Rezoning Transportation Analysis
Petition Number: Insert Zoning Petition #2022-032
General Location Identifier: 16720541

Date	Description
07-26-22	First Review (PDM)

Transportation Summary

**RZ-2**

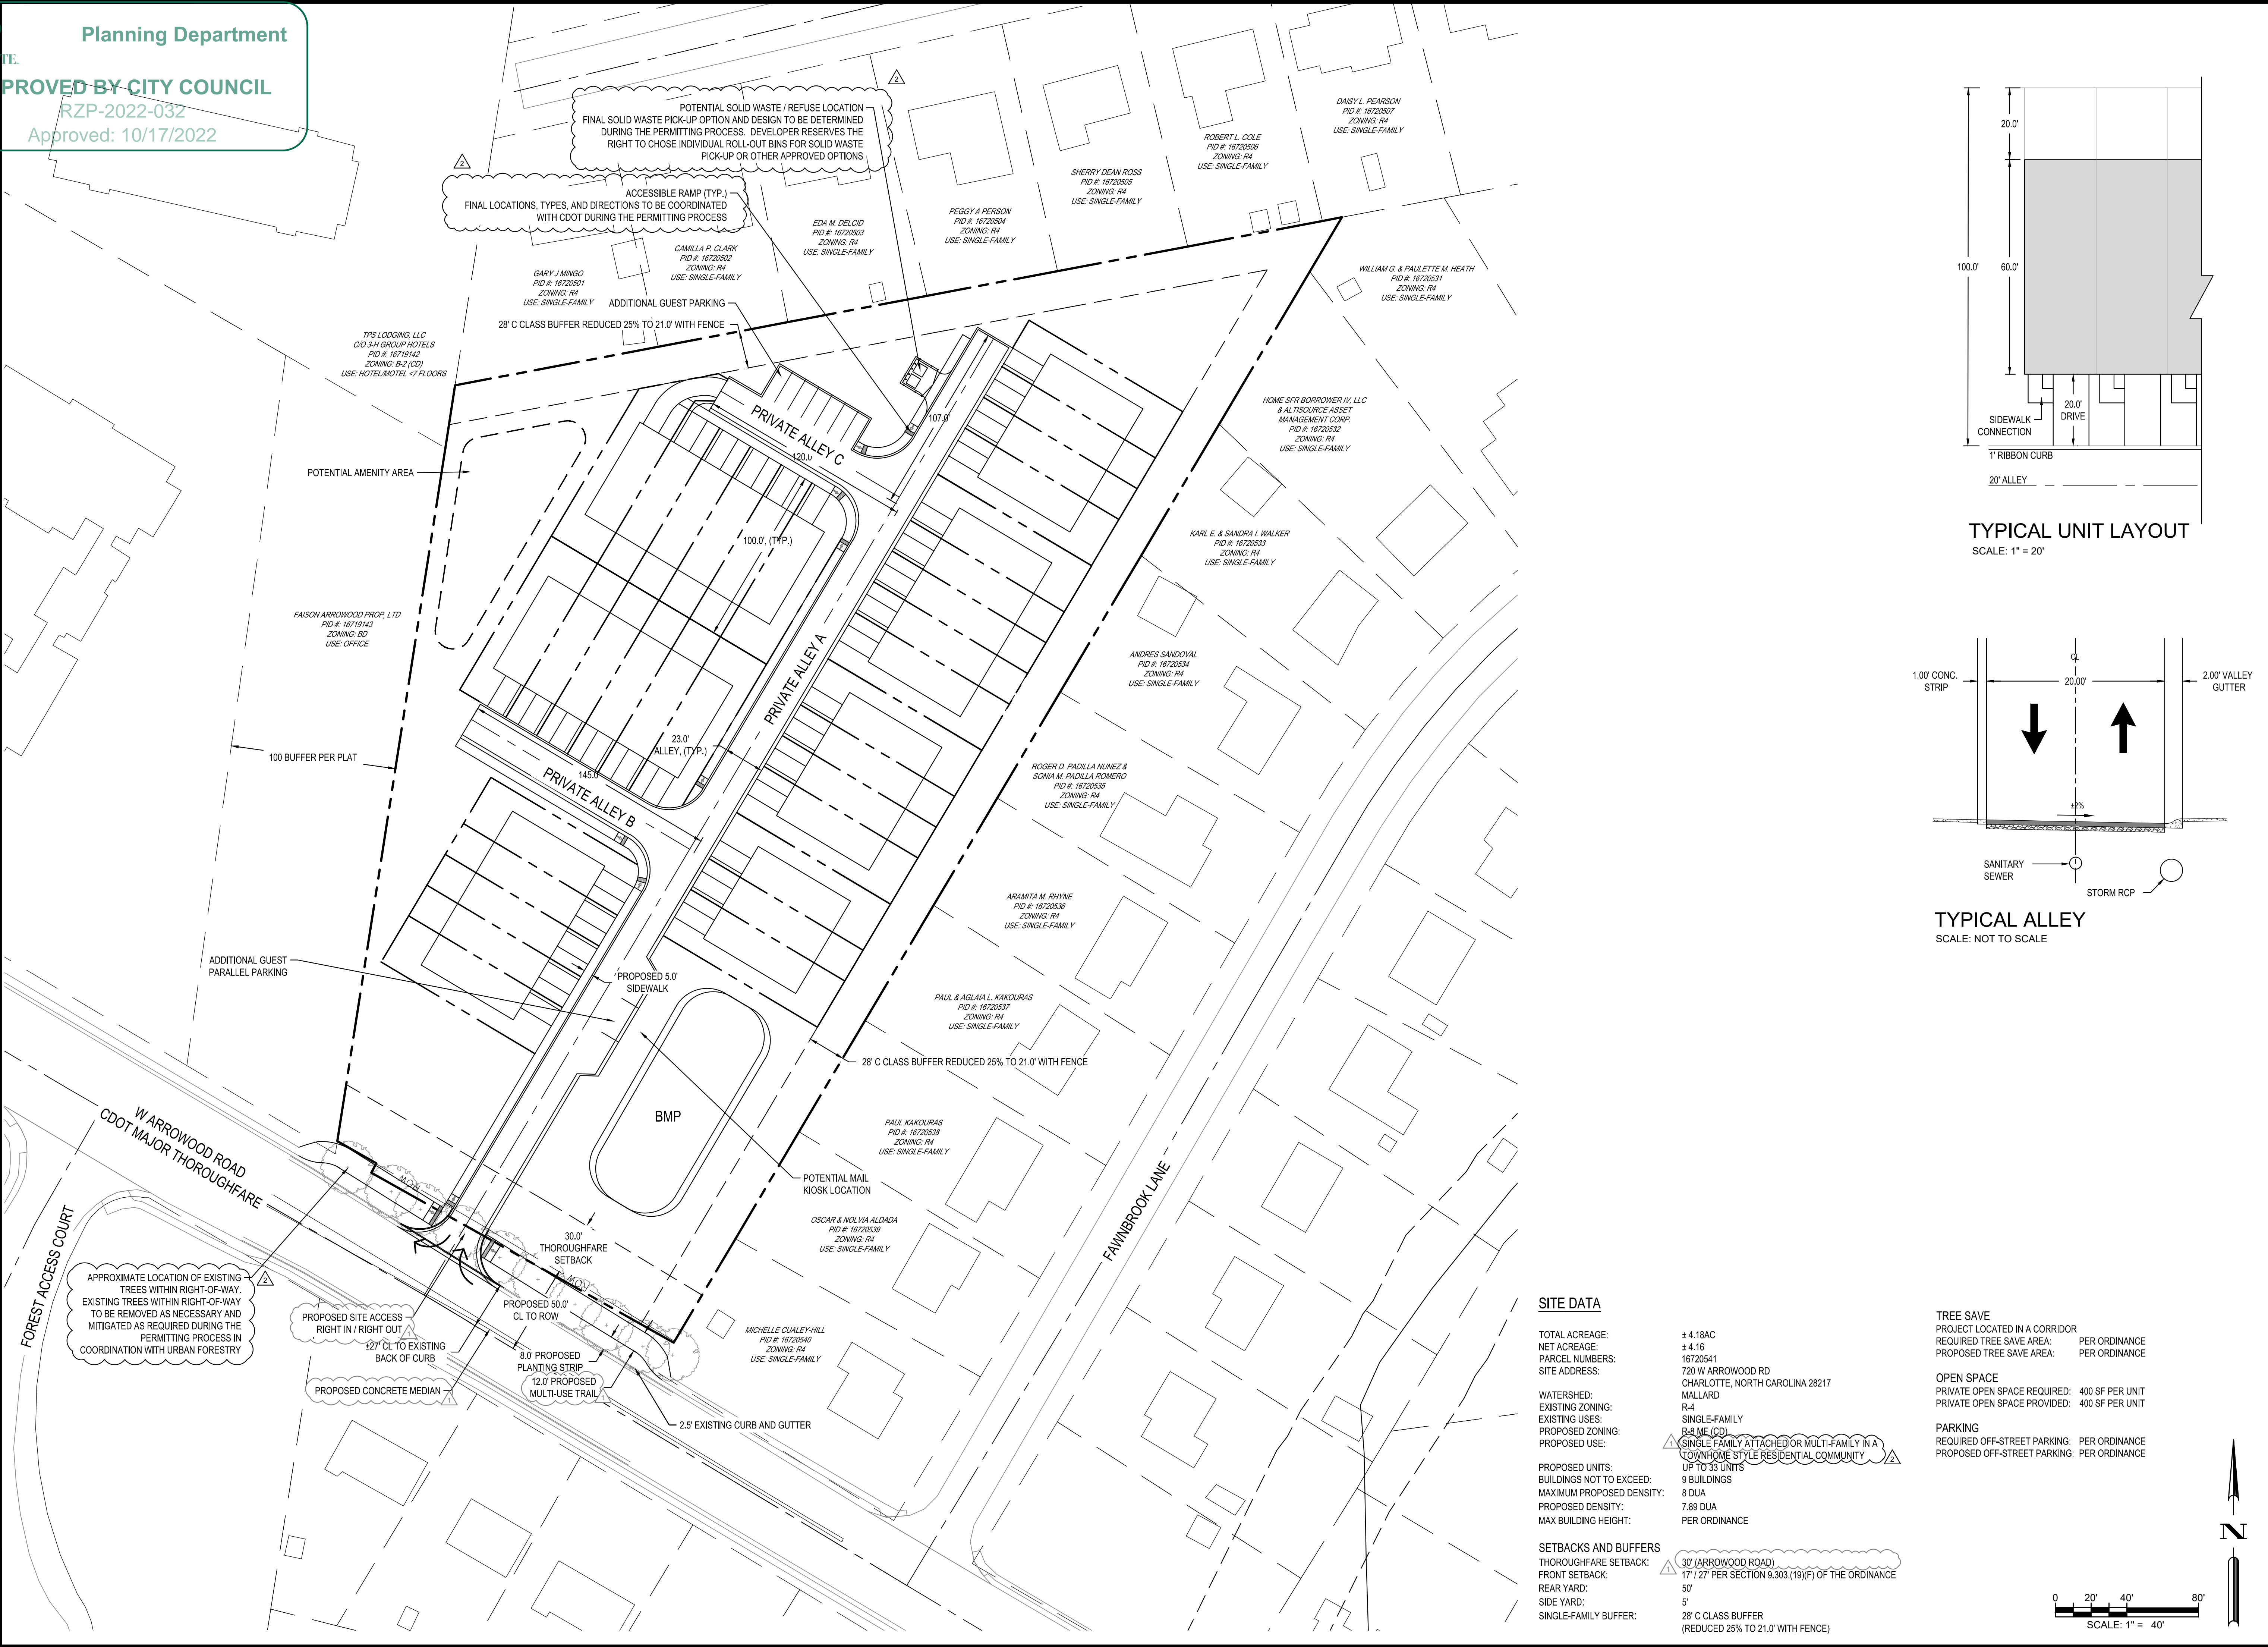
Label and dimension the curb and gutter from the centerline for each road on the site plan.
2. **Traffic Study:** A Traffic Impact Study (TIS) is not necessary for the complete review of this petition due to the site generating less than 2,500 daily trips. If during the permitting process the site generates more than 2,500 daily trips, then a traffic study will be required.

3. Site plan and conditional note(s) revisions are needed to commit to installing a 12' multi-use path along Arrowood Road to meet the City Charlotte BIKES Policy.

4. Revise site plan to dedicate 50-feet of right-of-way from the Arrowood Road centerline if it does not exist. The site plan shall label and dimension the right-of-way from the road centerline. Ensure a continuous 50ft ROW is provide at a minimum for the full length of the site.

5. Add conditional note stating, "Intersection sight distance will be met per CDOT's Sight Distance Policy, dated May 2003, at the intersection of Arrowood Road and the proposed private street." Proposed private street off Arrowood Road may be subject to relocation if intersection sight distance cannot be achieved.

6. Site plan and conditional note(s) revisions are needed commit to installing a required Left-Turn Lane into the site on Arrowood Road into the site. label and dimension left-turn lane on site plan and add conditional note describing all turn lane design requirements. The existing left turn lane should be restriped to accommodate the new street.

7. Site plan and conditional note(s) revisions are needed to commit to extending the proposed sidewalk and ADA compliant sidewalk ramps closer to the intersection of Private Alley B.
